Memorandum

To:	Norine Allerdice	Date:	October 27, 2022
From:	April Ng		
Project:	Butenwieser/Wiley Residence 6838 96 th Ave SE Mercer Island, WA 98040 King County APN 302405-9010	File No:	2205-199
Subject:	Building Permit Review 1 Response

The comments are restated below, followed by responses. Updated drawings have been clouded with Revision 1: 10/27/22 Building Permit Resubmittal.

C200B

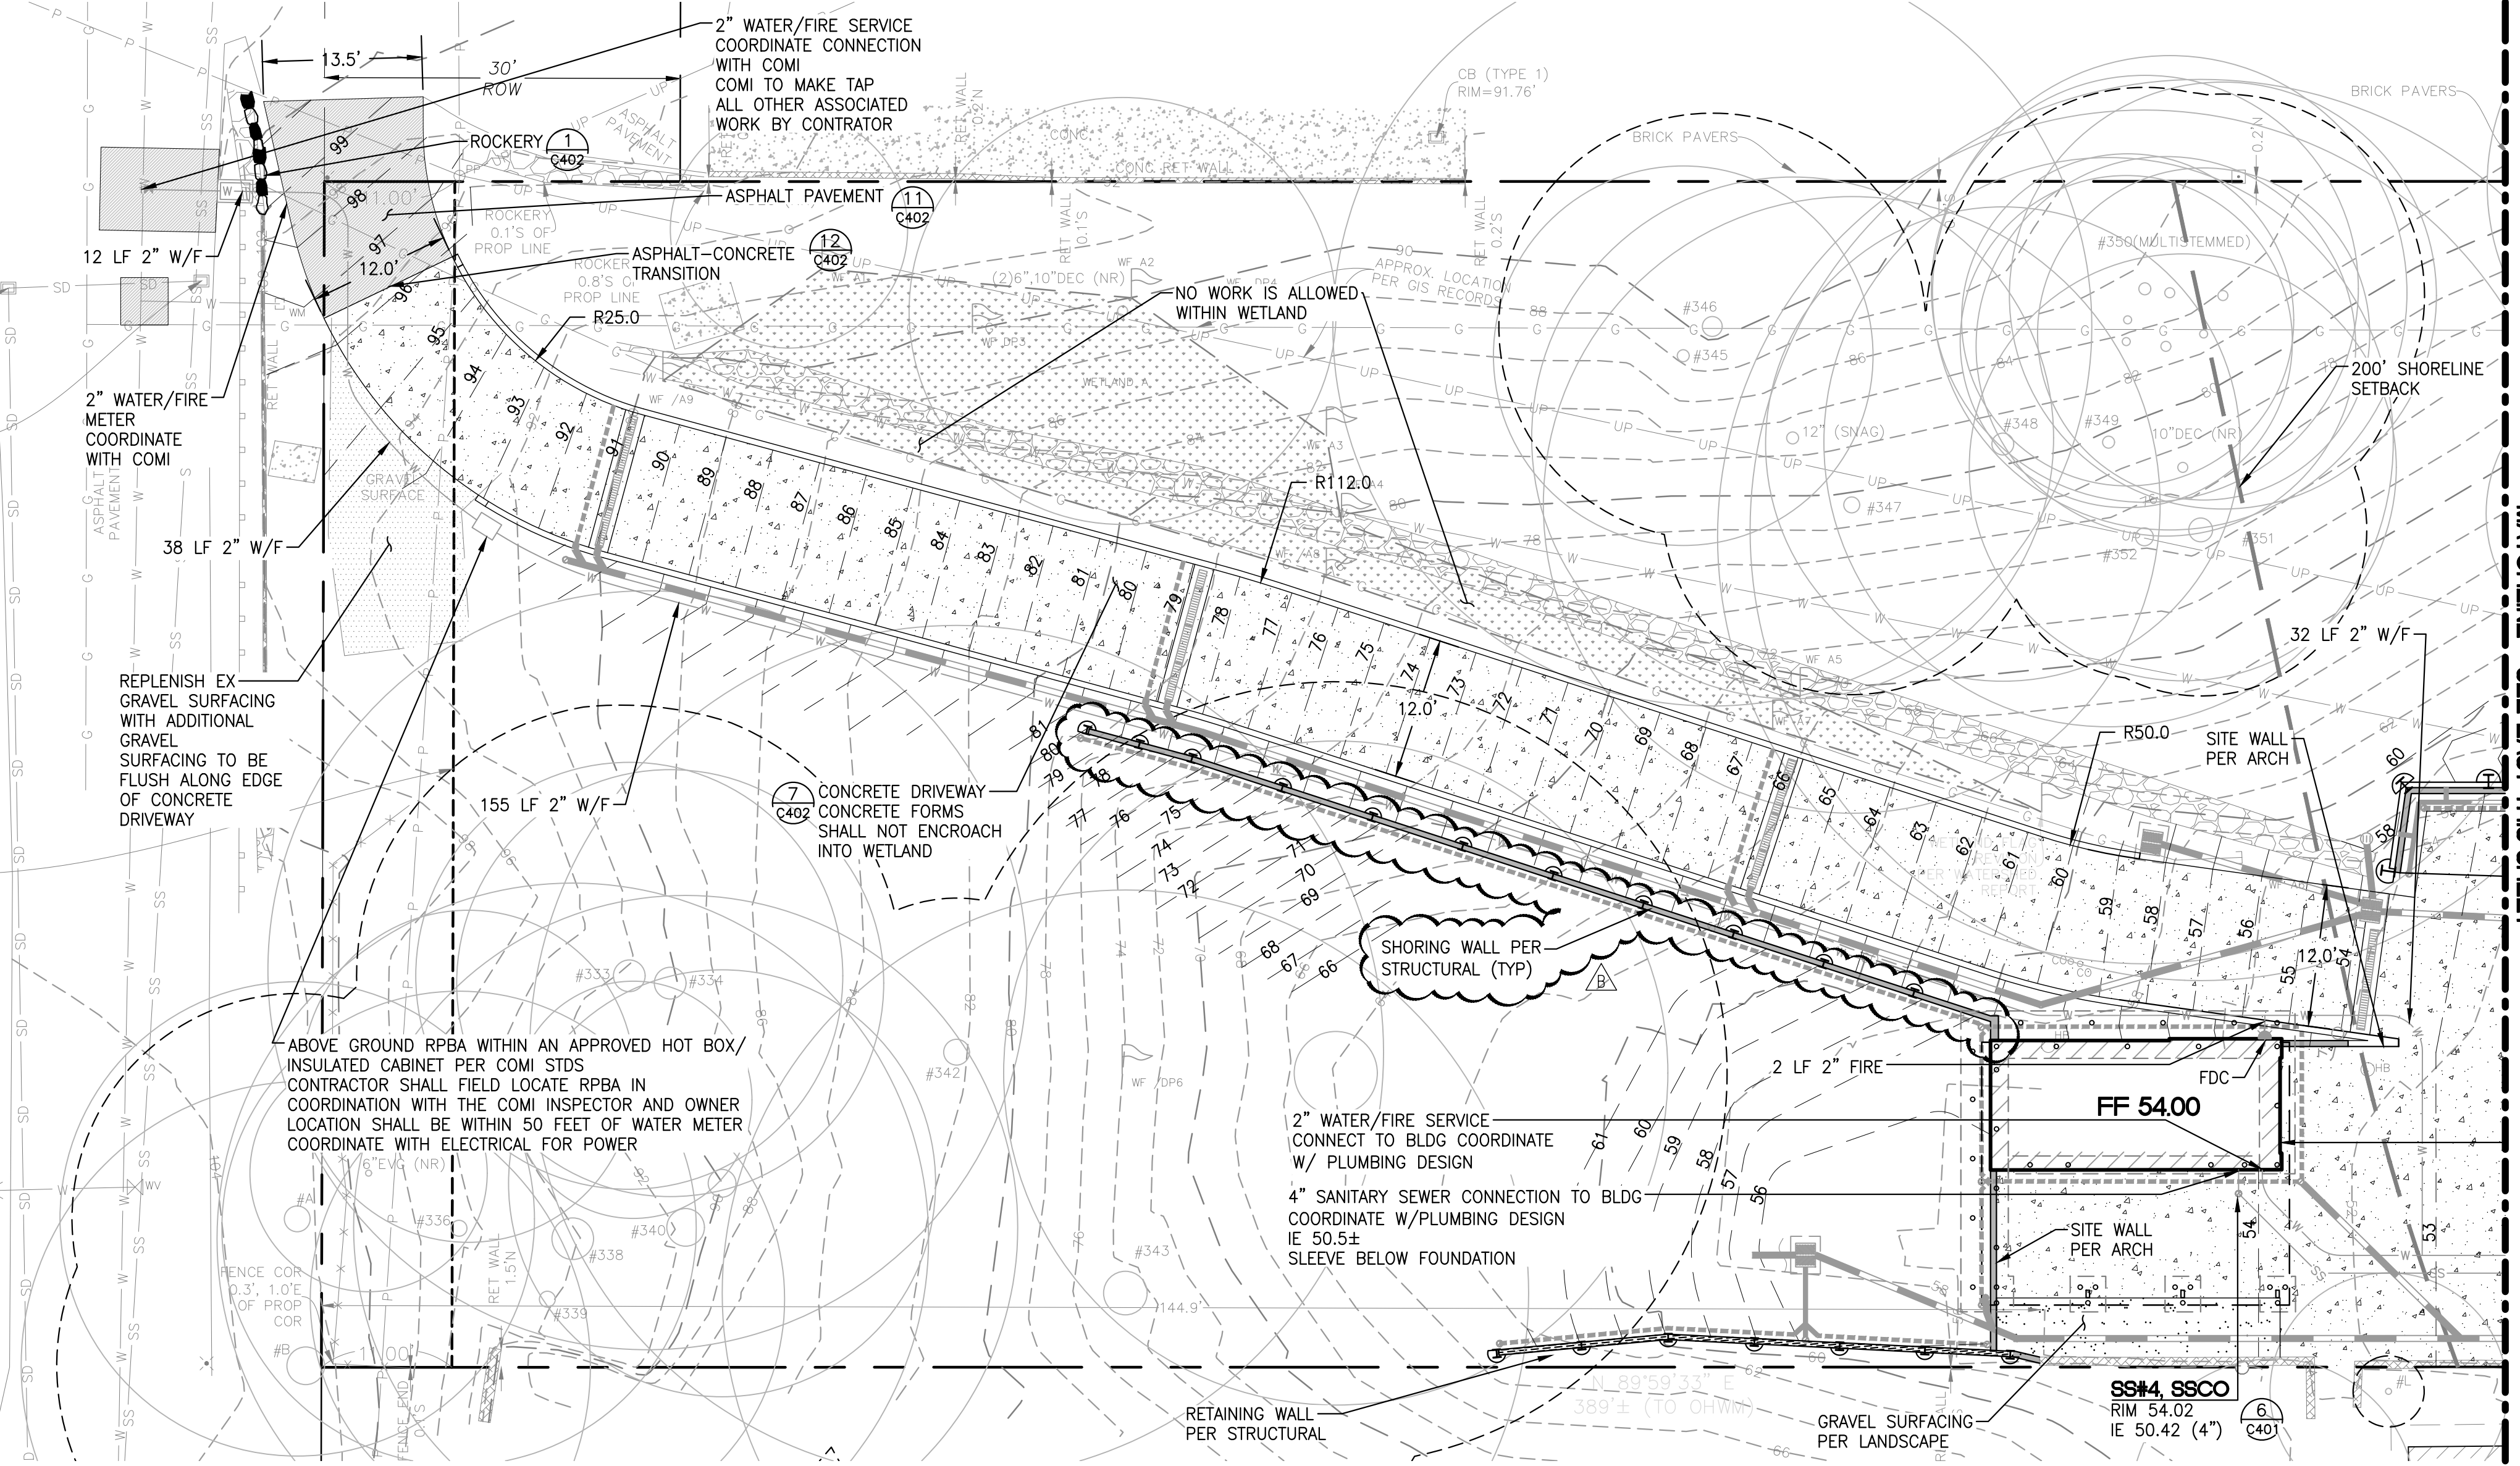
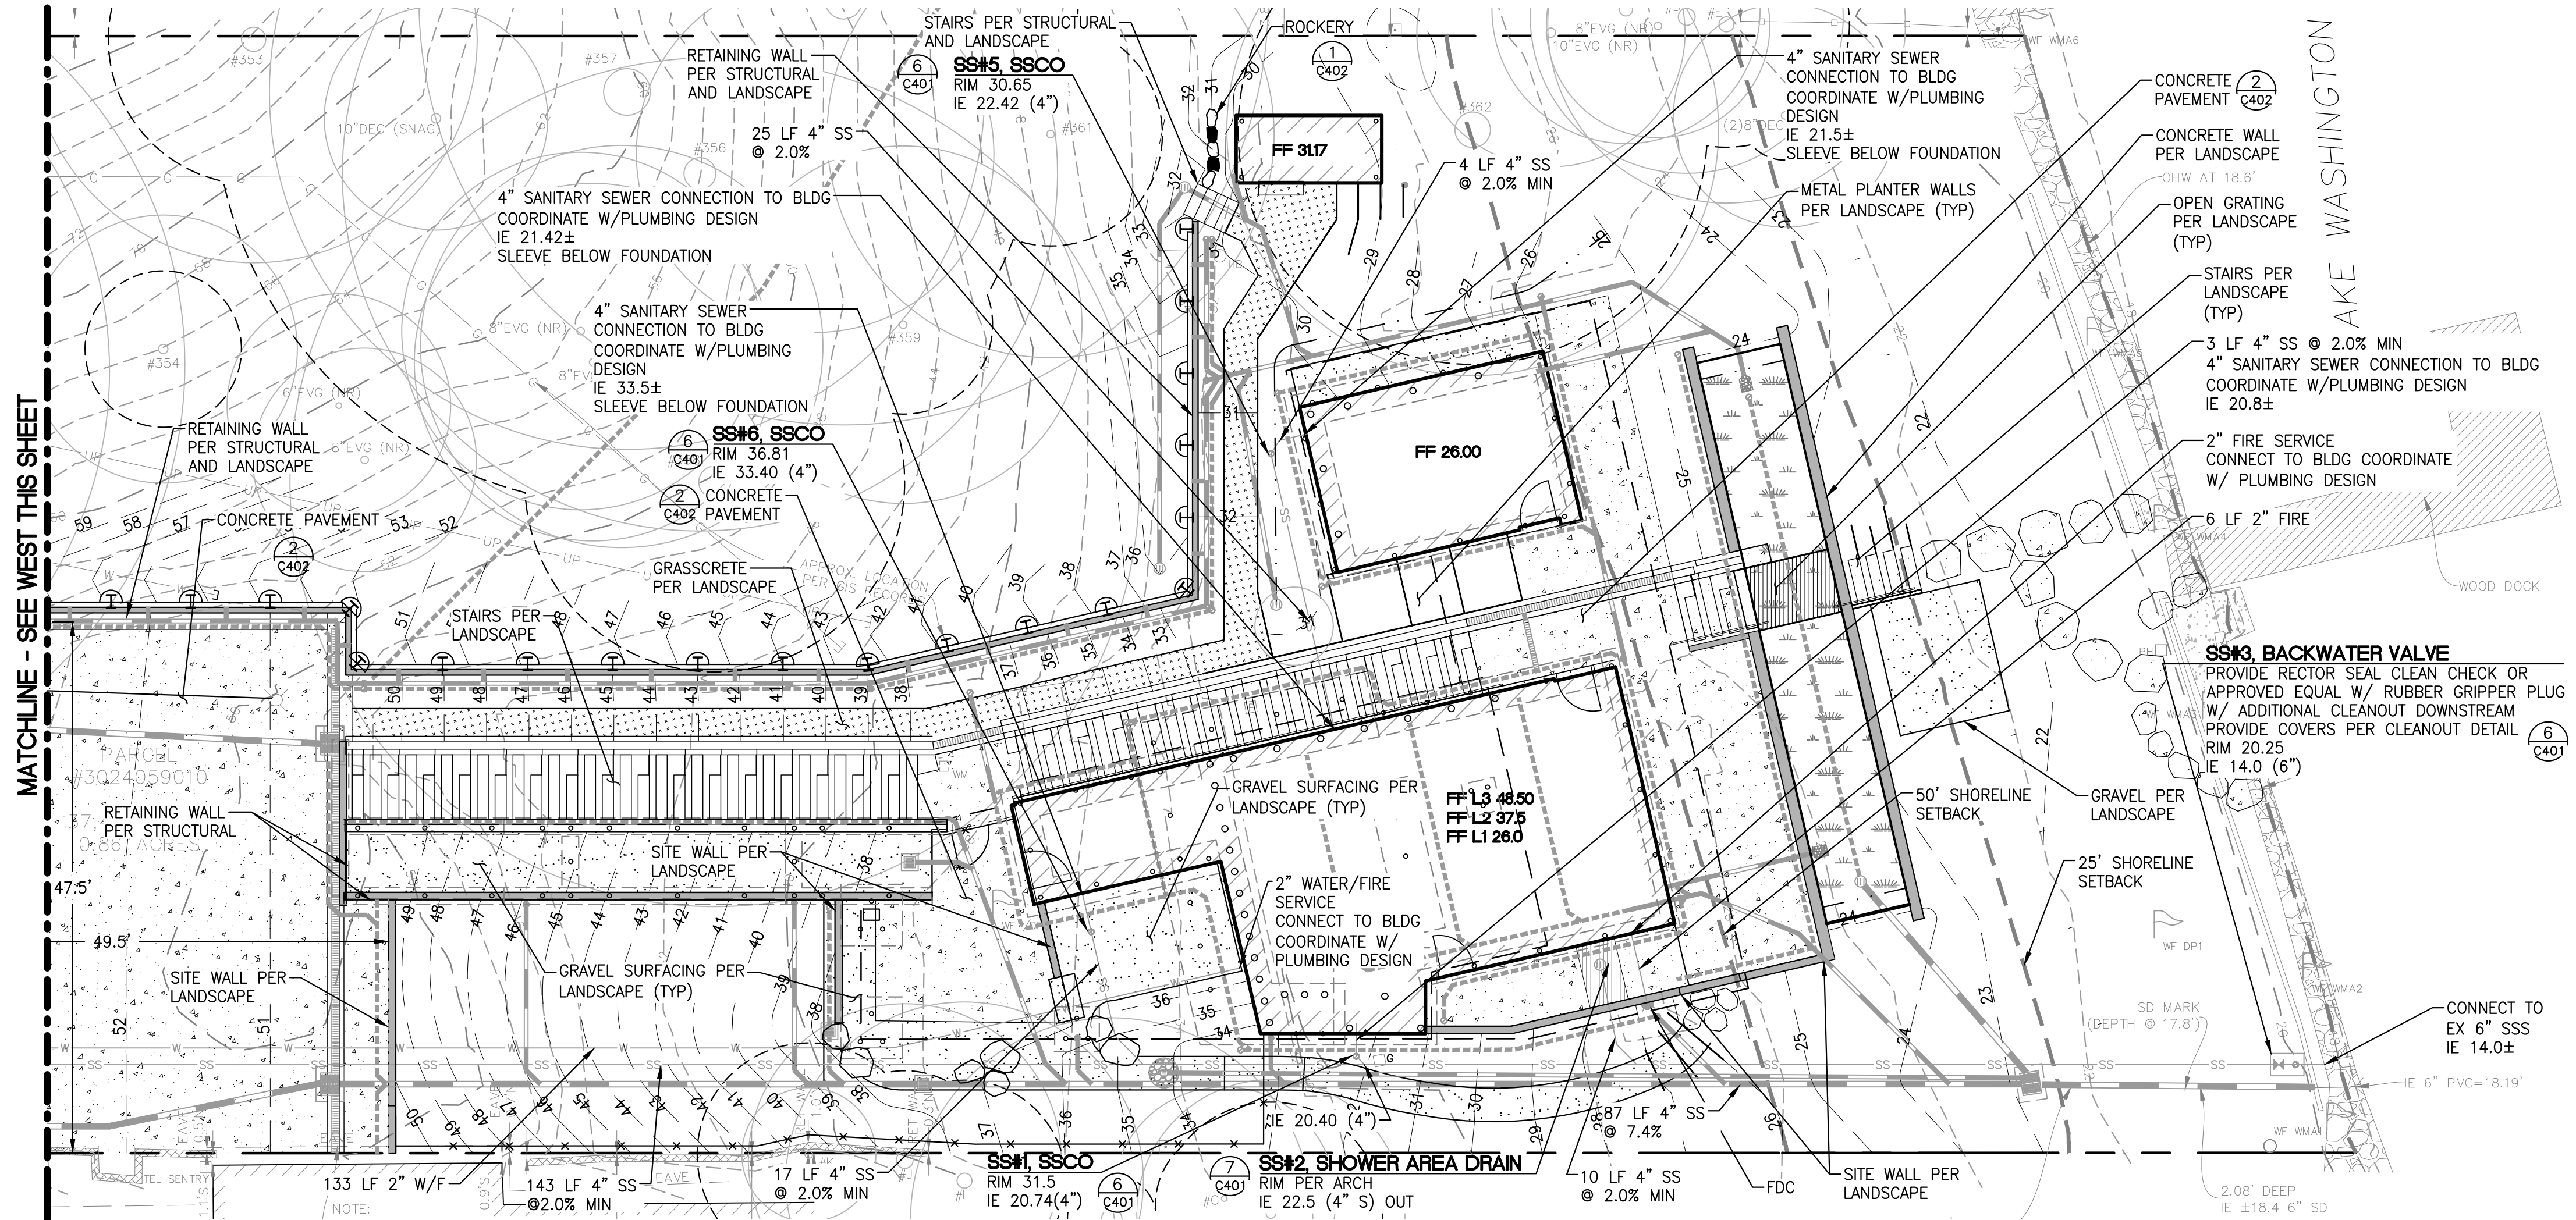
<p>C200B Is there a detail showing how the walking path going through the bioretention area?</p>	<p>Bridge over the bioretention area is shown on 1/L404</p>	<p>1/L404</p>
<p>C200B</p>	<p>The bridge will be located above the ponding depth of the bioretention area and will span the pond. The soil section</p>

Please explain how the planting specific for the bioretention will work with a bridge on the top.	and planting will be continuous throughout the pond and below the bridge.	
C200B Are there footing and roof drainage connections for this building?	The proposed shed will be on piers. It has a shed roof that slopes west to east. The downspouts on the east side will be routed below the structure to be connected into the system at the northwest corner.	
C200B Please verify the size, material and the conditions of the existing storm	Outlet pipe to Lake Washington is a 6-inch pvc pipe. 	
C200B No daylight the downspout drainage.	Downspout has been tied into storm drainage piping.	
C300 See comments on C100.	New 2-inch Fire/Water service has been included on C300.	
C400 Please show the inlet pipe and discharge pad on this detail, including the invert elevation.	Inlet pipe and pad has been indicated on the bioretention section, 3/C400.	3/C400
